Peartree Hill Solar Farm

Environmental Statement Addendum Revision 2

Application Document Ref: EN010157/APP/8.2

August 2025

Client	Project Name
	Peartree Hill Solar Farm
Designer	Drawing Title
	Environmental Statement Volume 4, Appendix 15.2 - Detailed Cumulative Landscape and Visual Impact Assessment, Appendix A, Figure 2 Proposed Development & 22/00824/STPLF - Field House Solar Farm ZTV

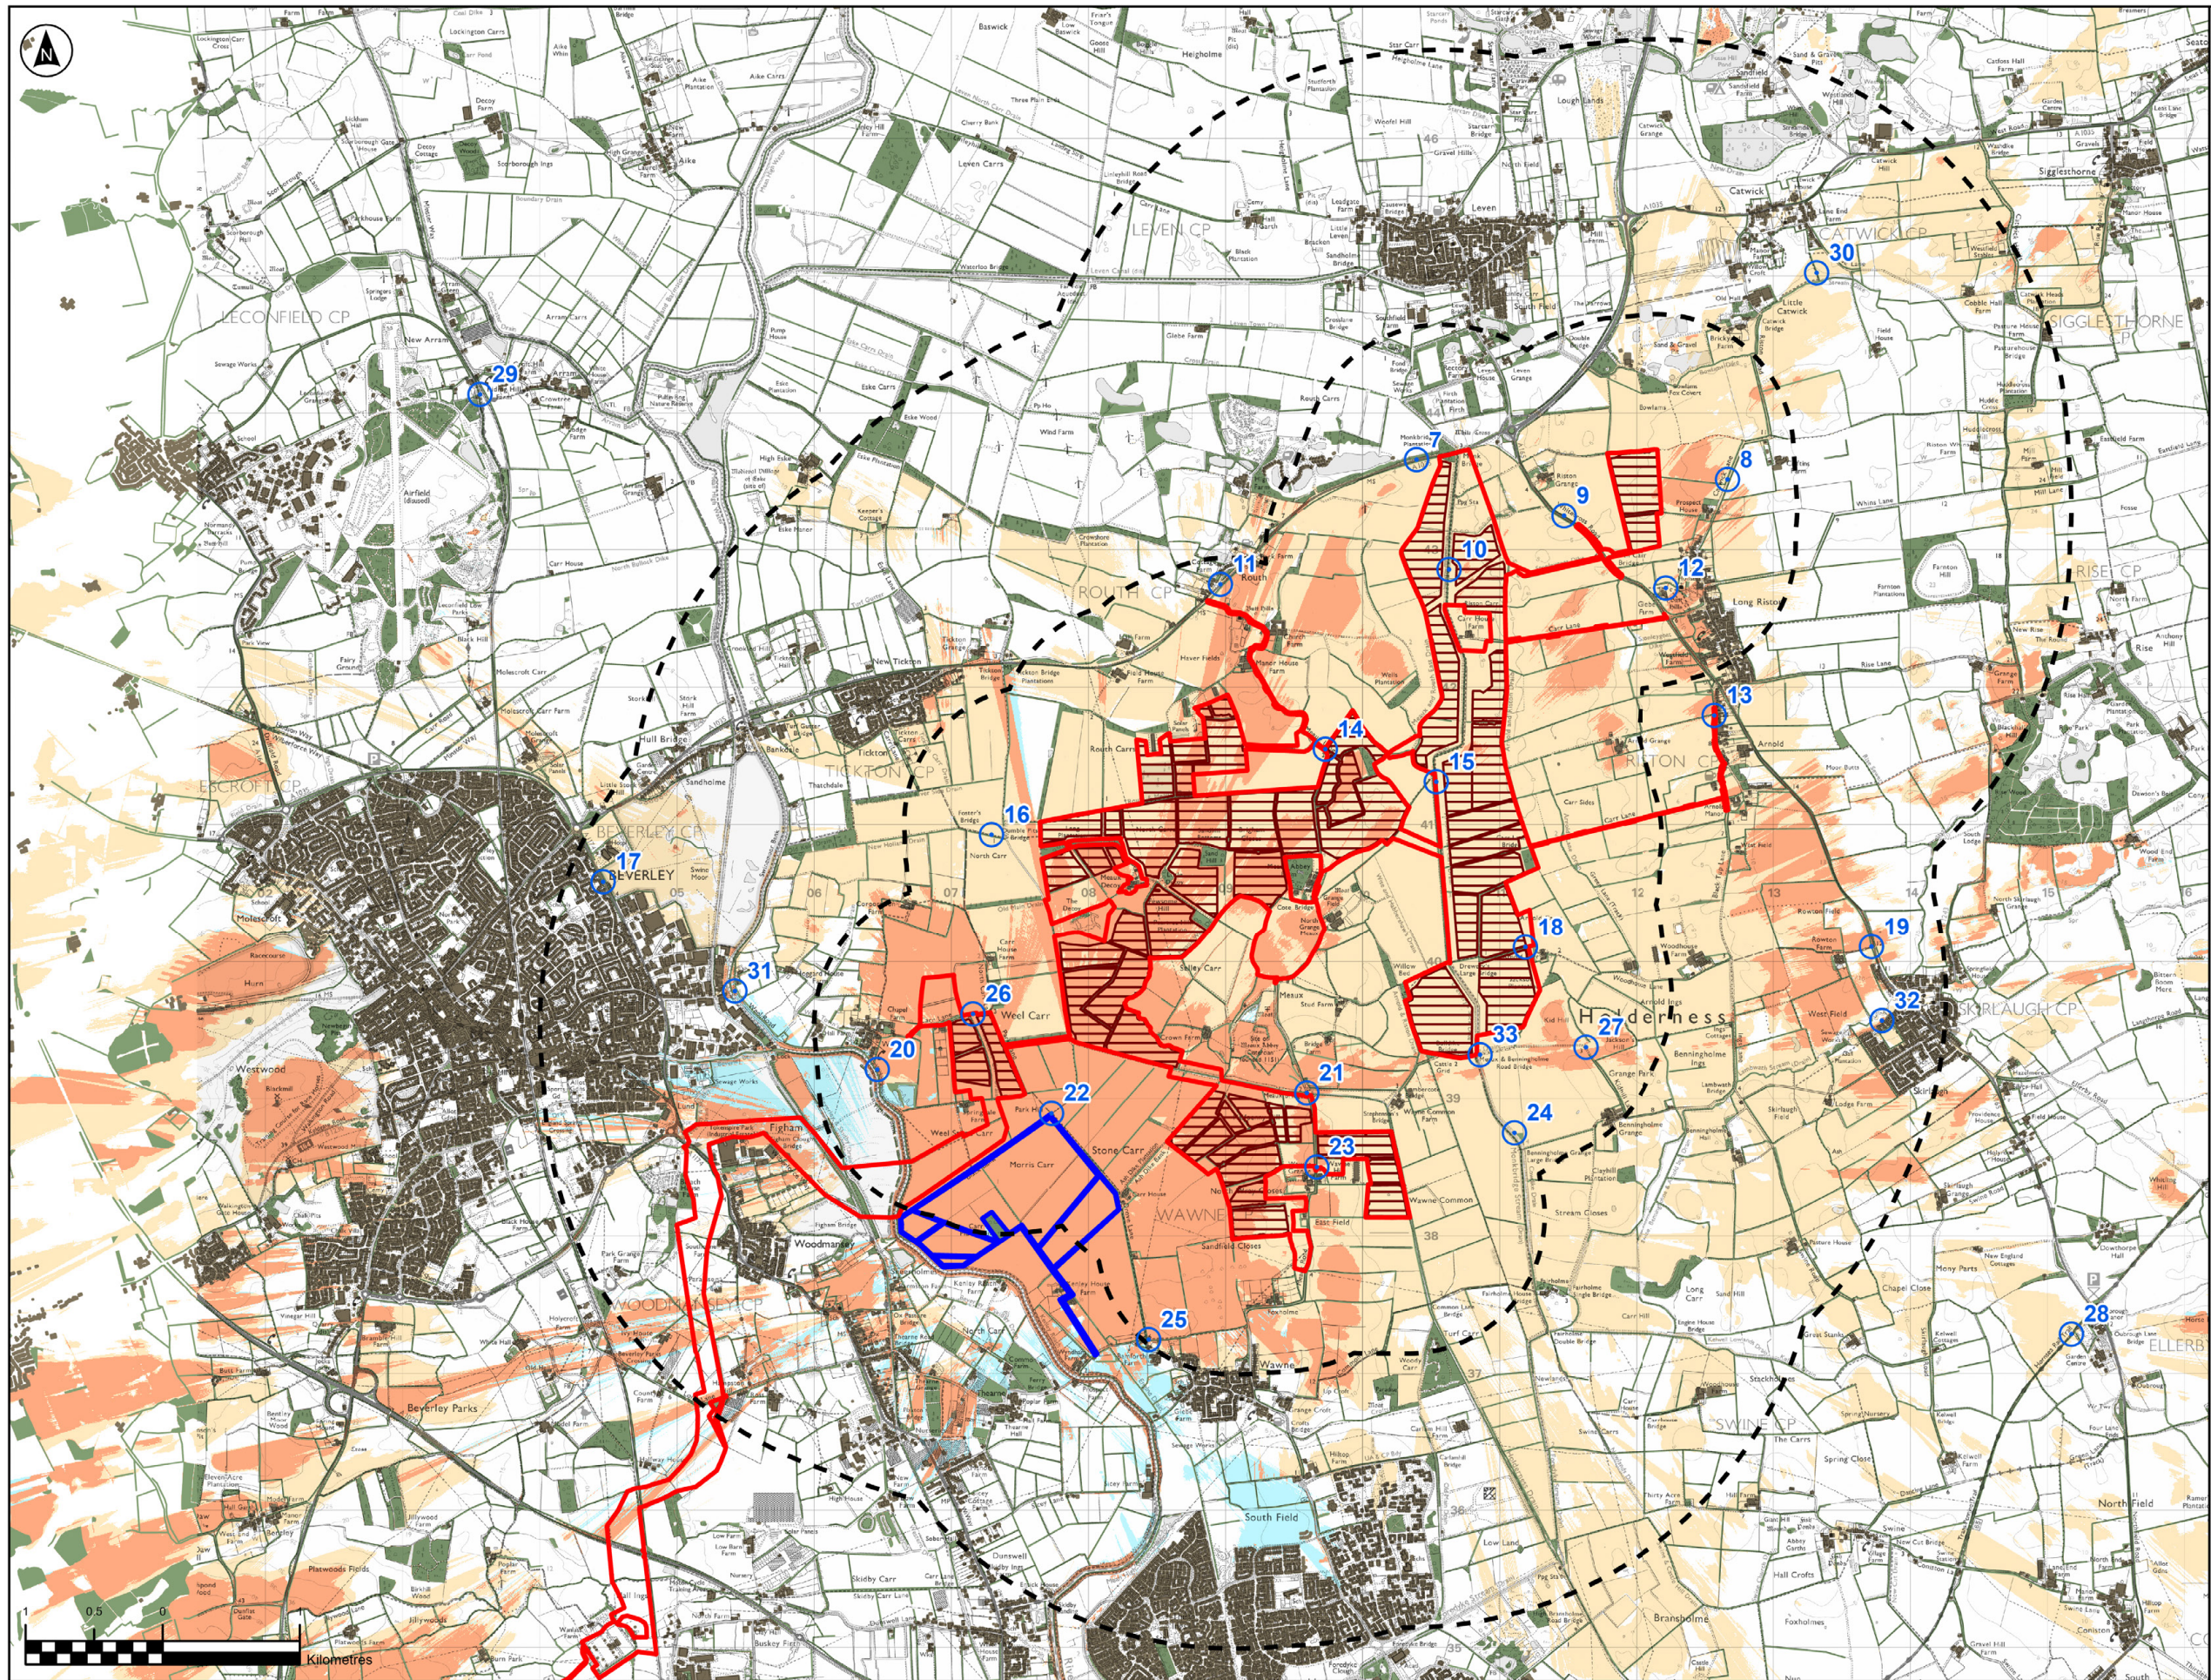
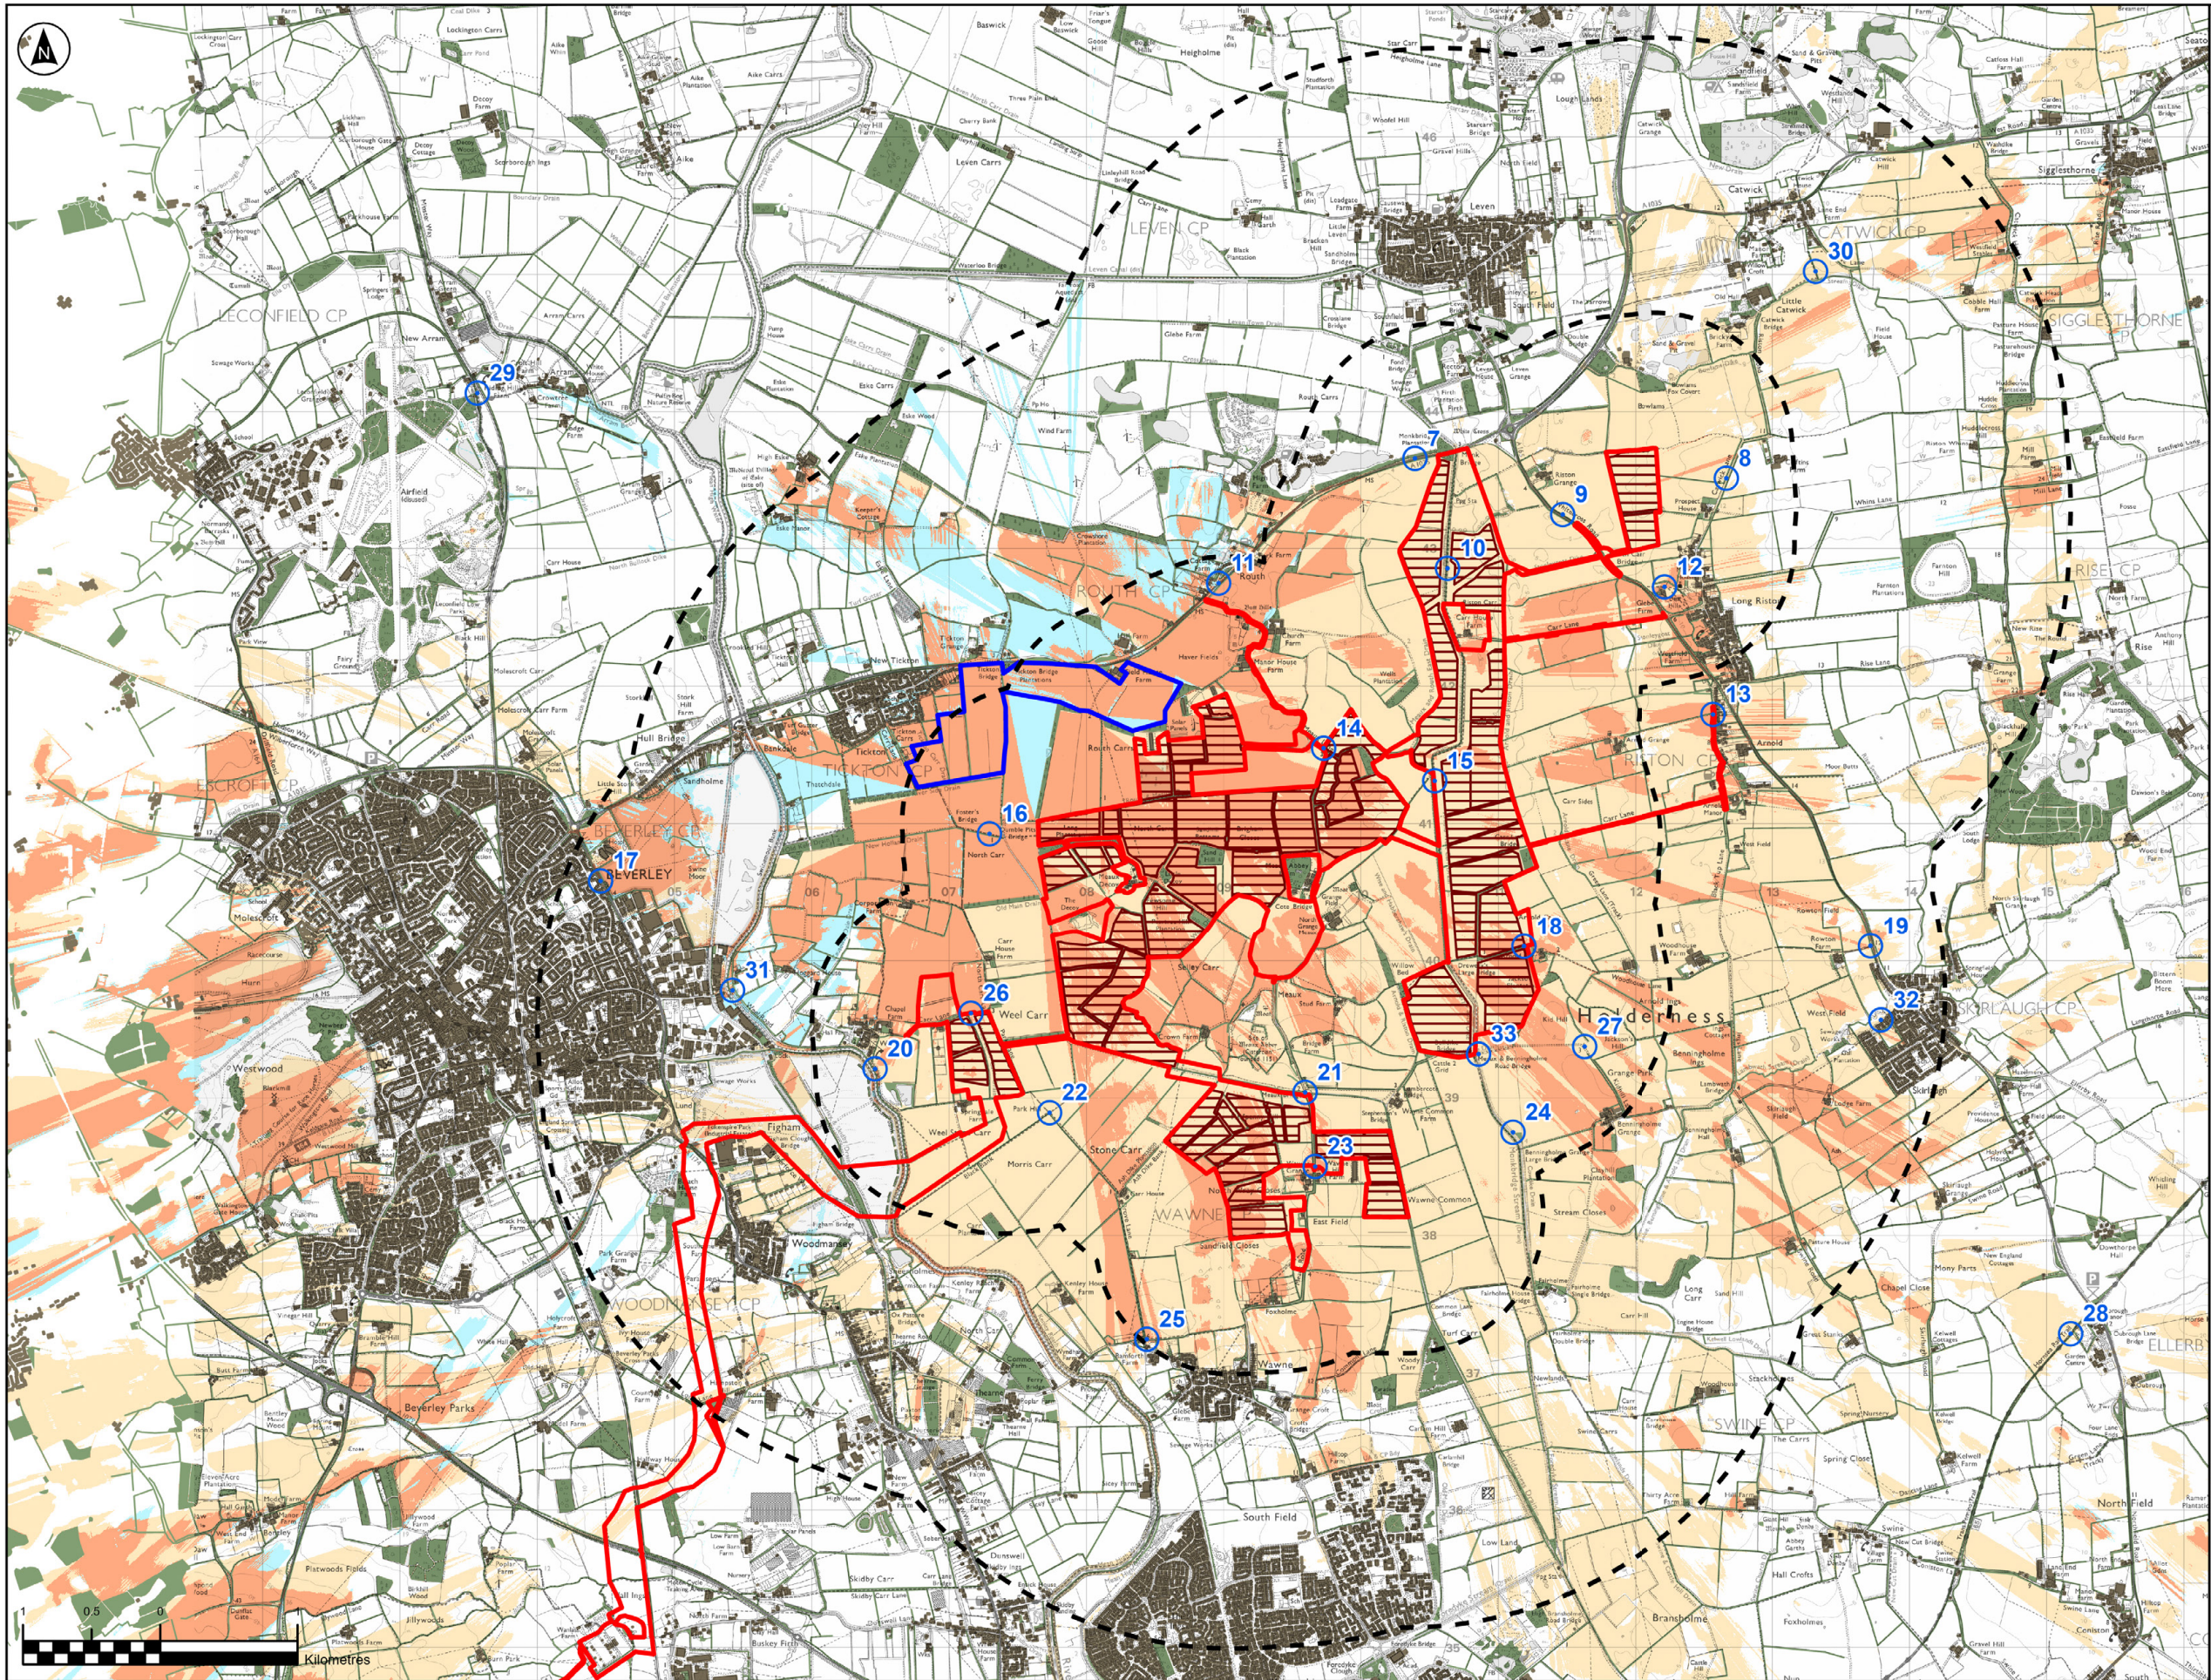
Document reference	Reason for amendment	ES Amendment August 2025
ES Volume 4, Appendix 15.2: Cumulative Landscape and Visual Impact Assessment [APP-144]	<p>Response to the ExA's First Written Questions [PD-008] (1.10.28 c)).</p> <p>Updates required to include a missing receptor ('Tickton PRow located between Tickton and Weel') in summary paragraph 3.8.4.</p> <p>When correcting the paragraph, the Applicant noted that three receptors had been included in paragraph 3.8.4 incorrectly. Updates required to move these receptors to a new paragraph.</p>	<p>A new paragraph 3.8.3 is added, which states:</p> <p>"For some receptors it is acknowledged that the addition of the five schemes considered in this cumulative assessment, in addition to the Proposed Development, would increase the geographic area where effects would be felt. However, they would not create significant cumulative effects beyond those already identified as being created by the Proposed Development alone. Those receptors to which this applies are:</p> <ul style="list-style-type: none"> • Meaux Lane/Meaux Road; <ul style="list-style-type: none"> ○ Cumulative effects identified, but overall not greater than those identified for the Proposed Development alone. • PRow Riston footpath no.2; <ul style="list-style-type: none"> ○ Cumulative effects identified, but overall not greater than those identified for the Proposed Development alone. • PRow Riston footpath no.1;
